Submission - Redfern Station Upgrade – New Southern Concourse

1- My comments on formalisation of a shared zone on Little Eveleigh Street, including:

Figure 5-3 Indicative cross section – Little Eveleigh Street and Marian Street shared zones

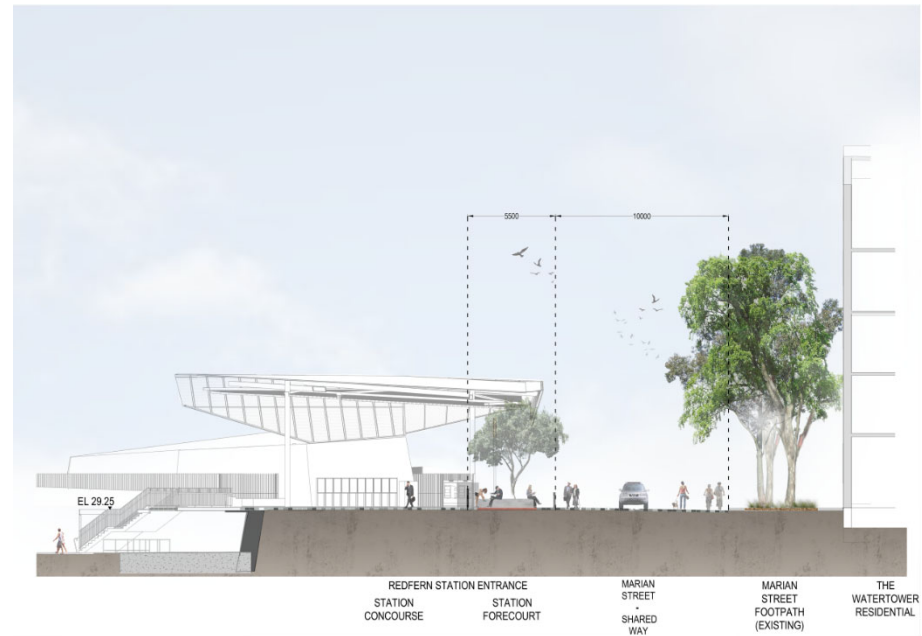
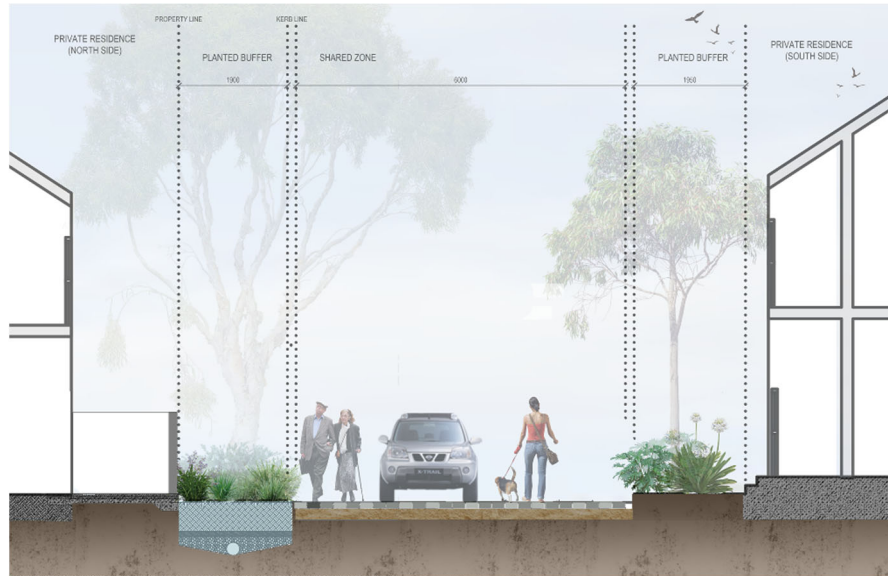
The key point that is relevant for Little Eveleigh street Shared zone is “can streets be crossed easily, safely and without delay?” There is no information in the EIS about how rail passengers will be able to safely exit and enter to and from Little Street into vehicle, cyclist traffic .

Two questions need to be answered in relation to the above analysis of the artist impressions of the shared zone - Will road works eliminate hill in little Eveleigh Street? And as research below shows traffic humps aren't a good idea for calming in shared zones, why does the EIS suggest their use to “calm” traffic in Little Eveleigh street?
